**From:** Finlay Gardner <Finlay.Gardner@arun.gov.uk>  
**Sent:** 04 March 2020 11:36  
**To:** Planning.Responses <Planning.Responses@arun.gov.uk>  
**Subject:** FW: LU/370/19/PL

Roof Detail Scale 1:100

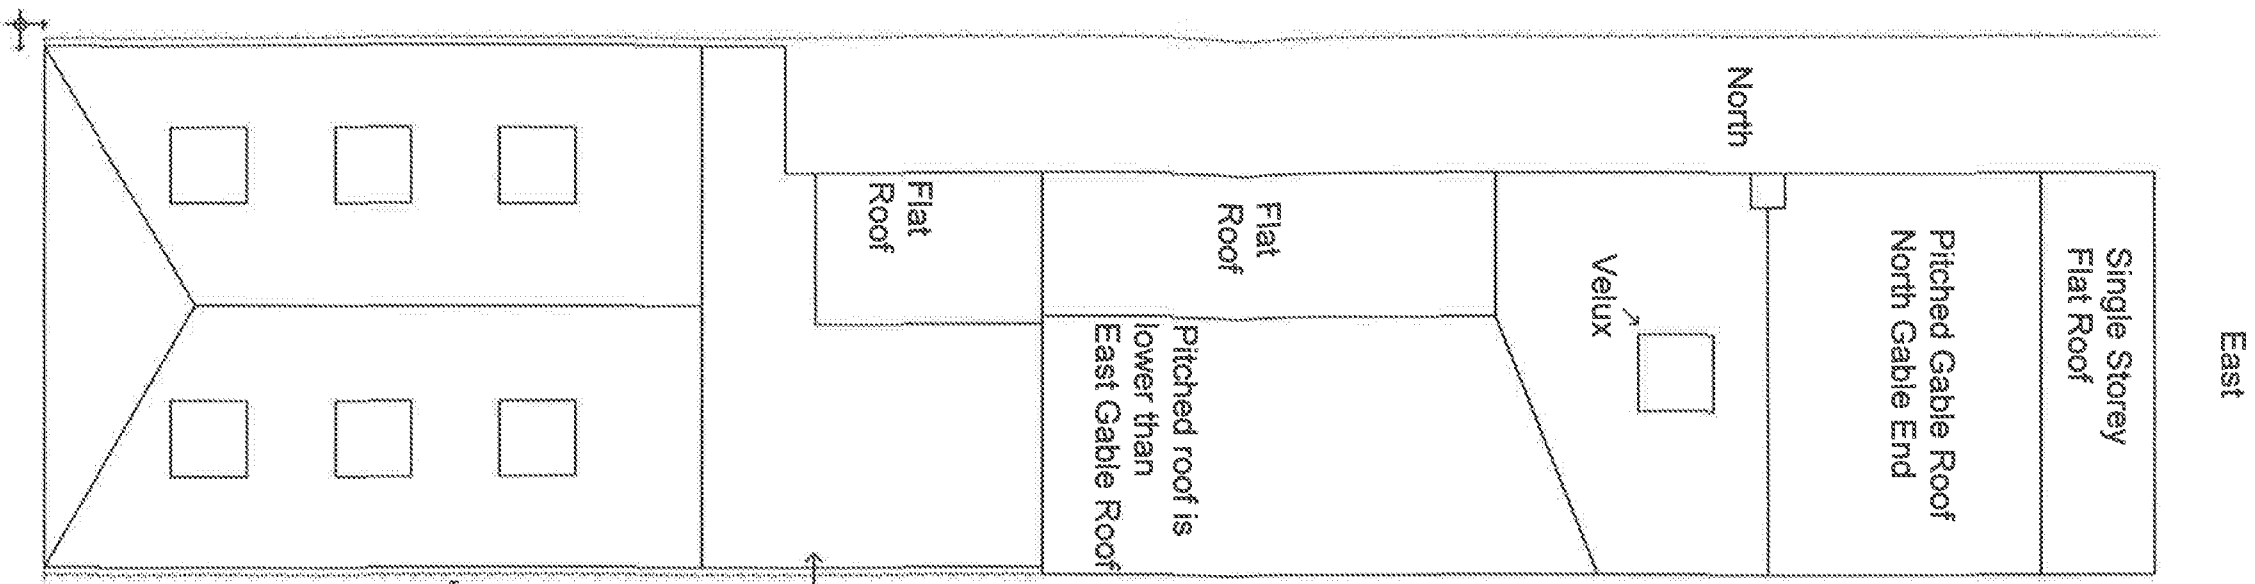
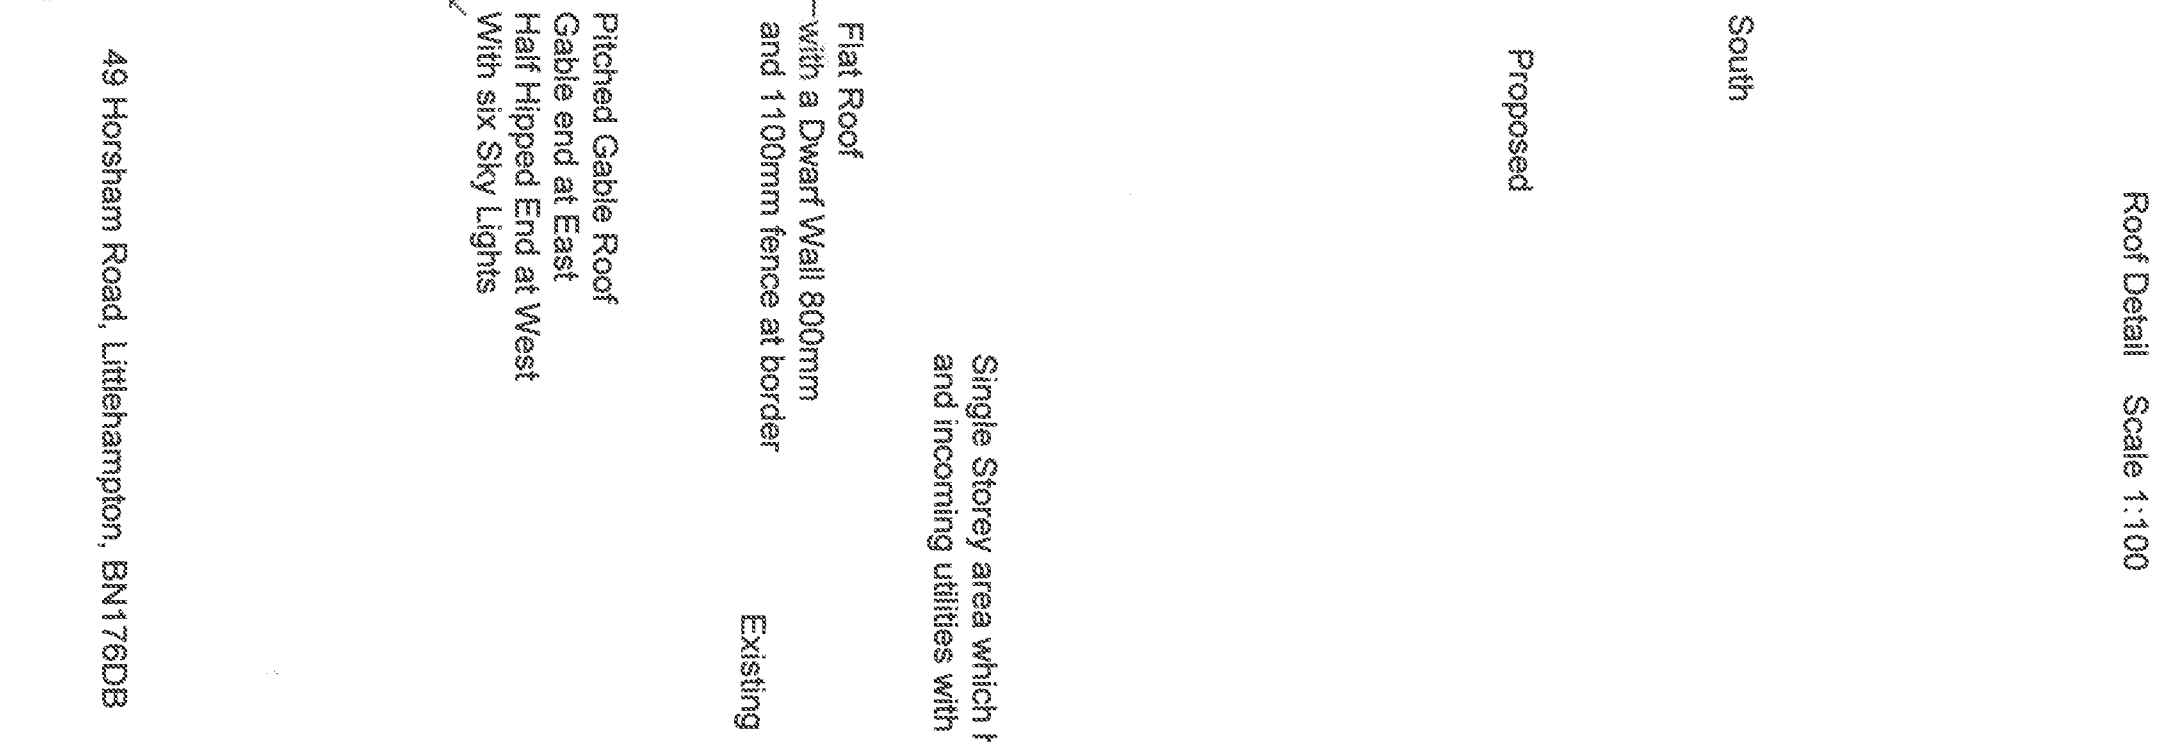
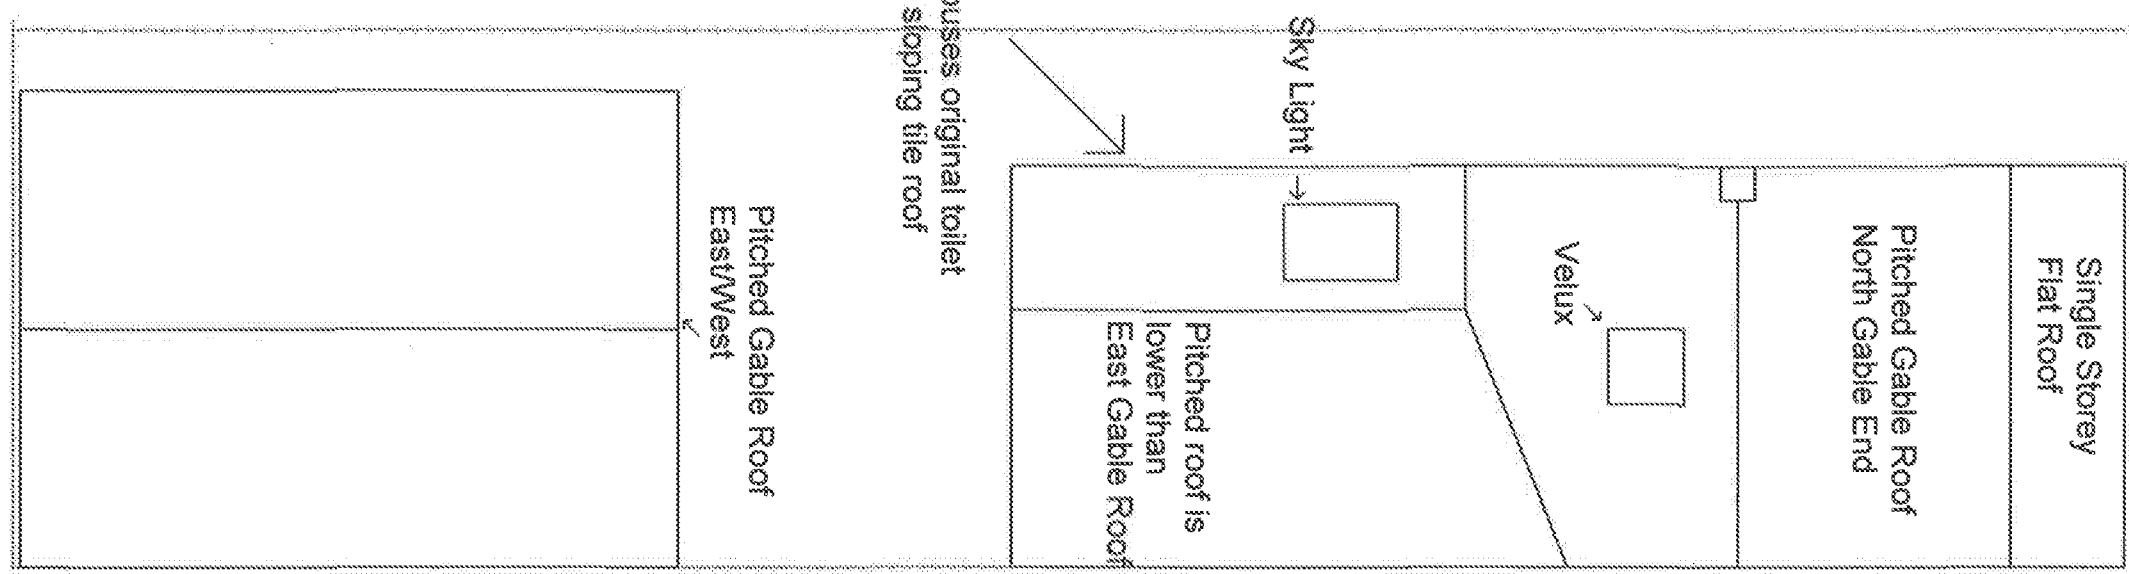
The proposal will also need a Roof Plan for existing and proposed and a First Floor Plan for the existing and proposed to add some clarity to the application.
